PLANNING APPLICATION COMMENT

Application: 2382/APP/2023/2906
Name: Broadwater Sailing Club Trustees and Main Committee
Address: Goldfinch Lane, Harefield, Uxbridge
Postcode: UB9 6FP
Telephone: 01895 824749 (Clubhouse phone)
Email: secretary@broadwatersc.org.uk
For or Against: COMMENT

This document is submitted by the Broadwater Sailing Club Trustees and Main Committee as **Comments** on the London Borough of Hillingdon Planning Application Reference: 2382/APP/2023/2906.

## LANDSCAPE MASTERPLAN // PENINSULA

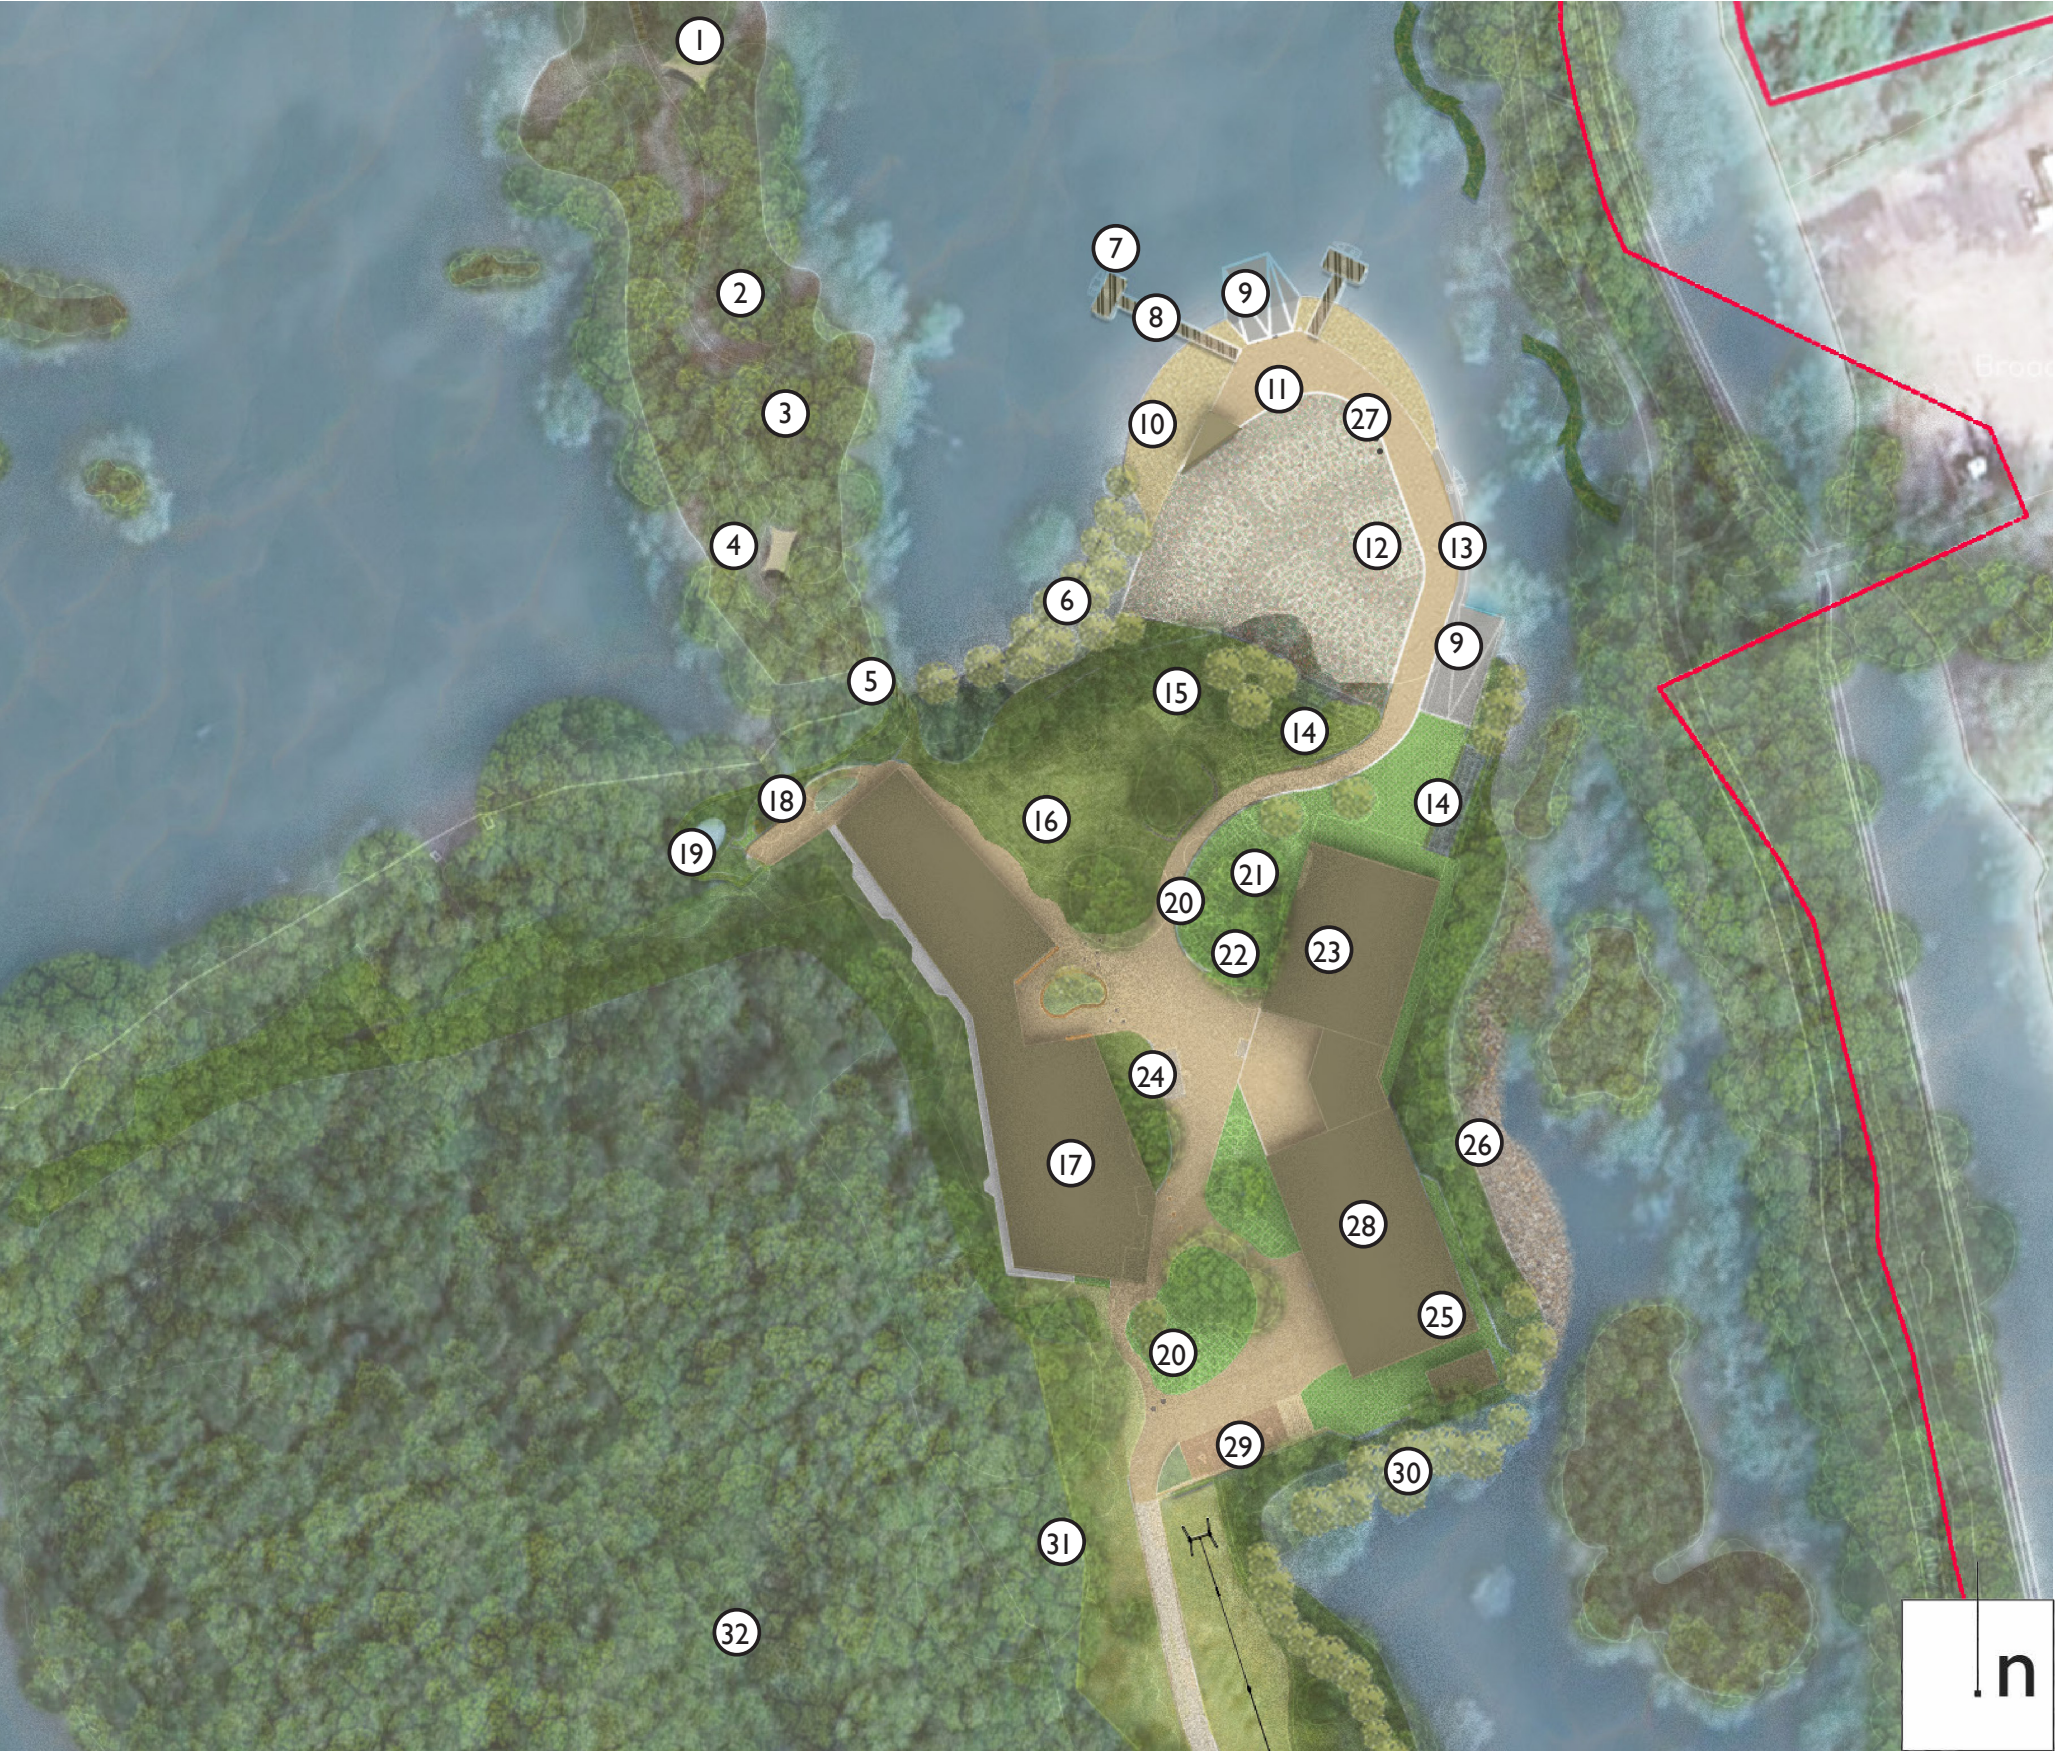
3. **Wind Obstruction:** The existing and proposed tree and willow planting will create significant wind shadows across the Eastern Channel and southern sailing area. This will severely degrade sailing conditions, particularly in the prevailing South-Westerly winds.

Figure 9: Existing and Proposed Sailing Areas

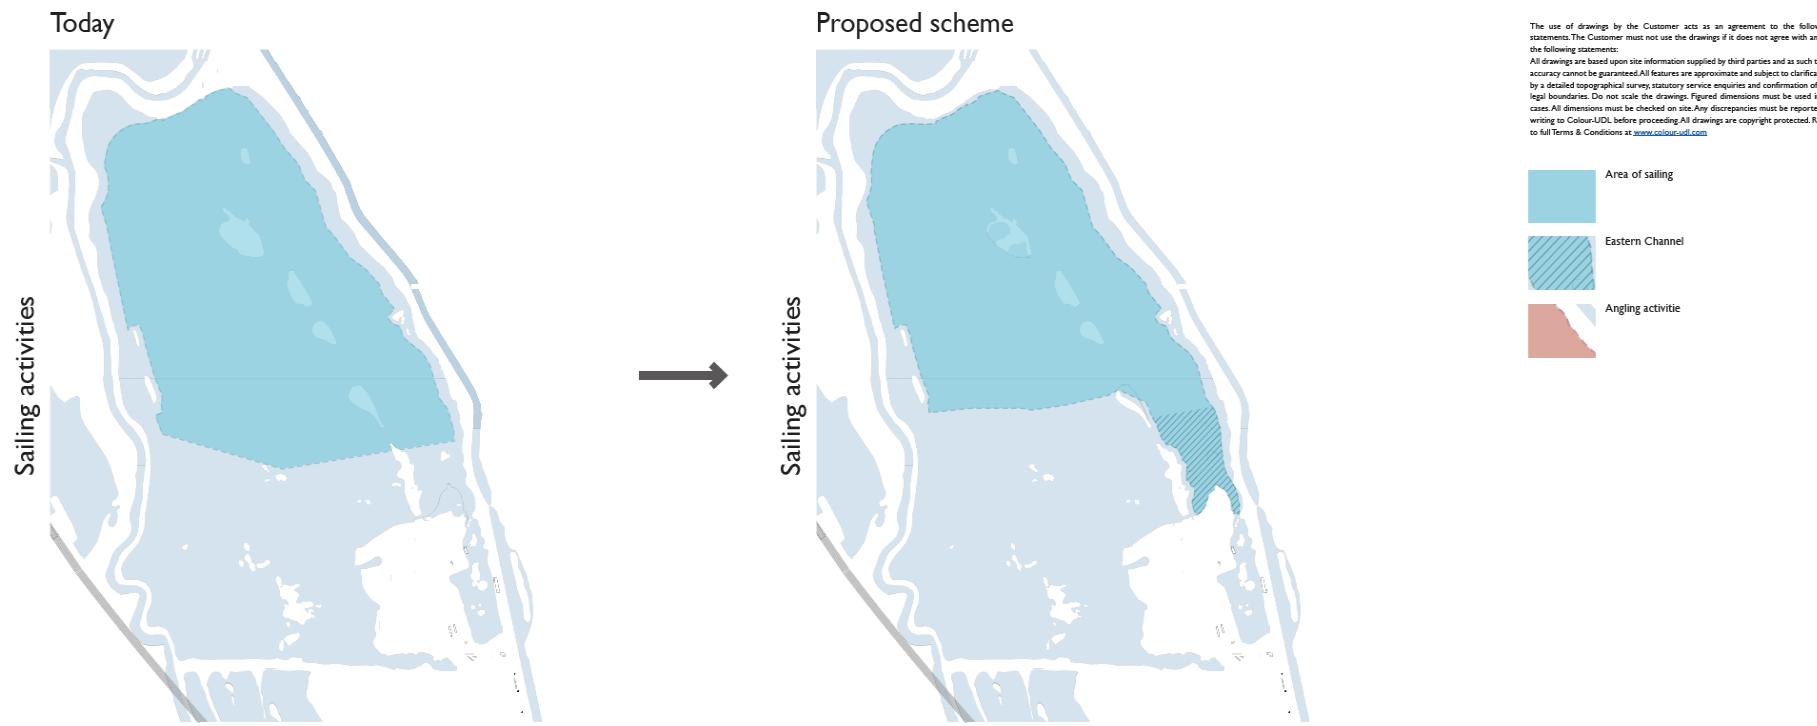
4. **Reduced Sailing Area:** The proposed sailing area represents a reduction in available water compared to the current sailing area as detailed in the current lease & planning permissions, reducing the capacity for racing and training. The sailing area calculation in the supporting documents are incorrect as it shows the area of shallows around the main island as being useable, which is incorrect unless this area is dredged as it is not deep enough to support dinghy sailing. The row of trees across the southern end of the sailing area significantly the current BSC lease area and this is addition to the loss of the bay at the north west end of the lake. This sailing area reduction is not offset by the water area in the Eastern Channel. The Eastern Channel is also a transit water to the sailing area and therefore should not be included in the sailing area calculation.

Figure 3.6: Site wide parking arrangements

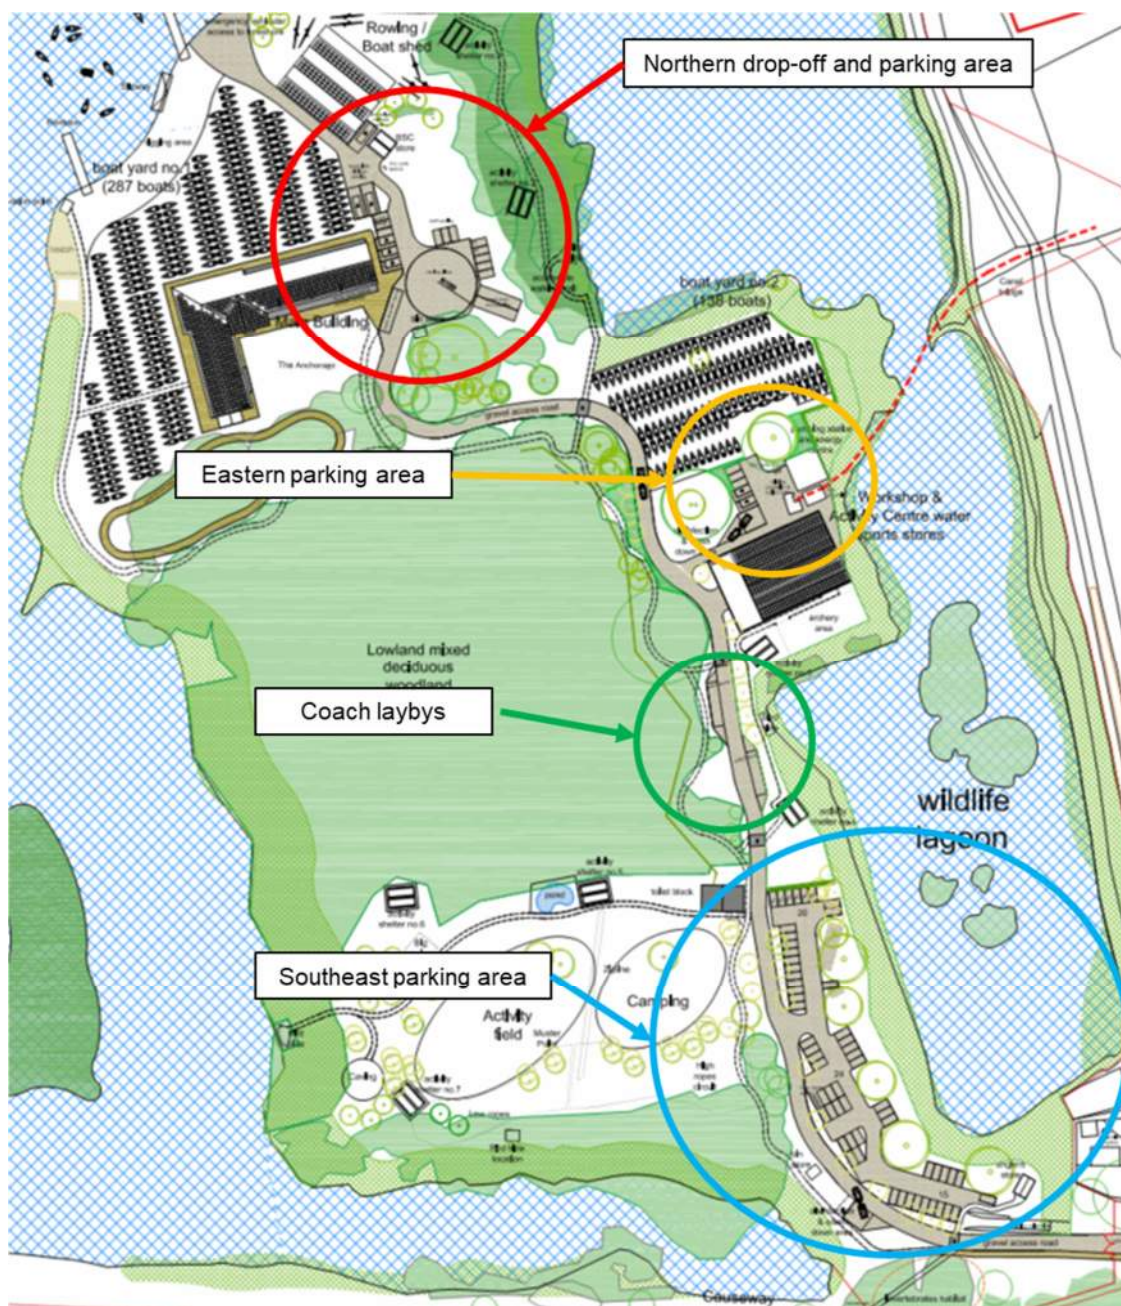
4. **Car Parking:** The proposed parking capacity is insufficient for peak times, which will lead to congestion and access issues.
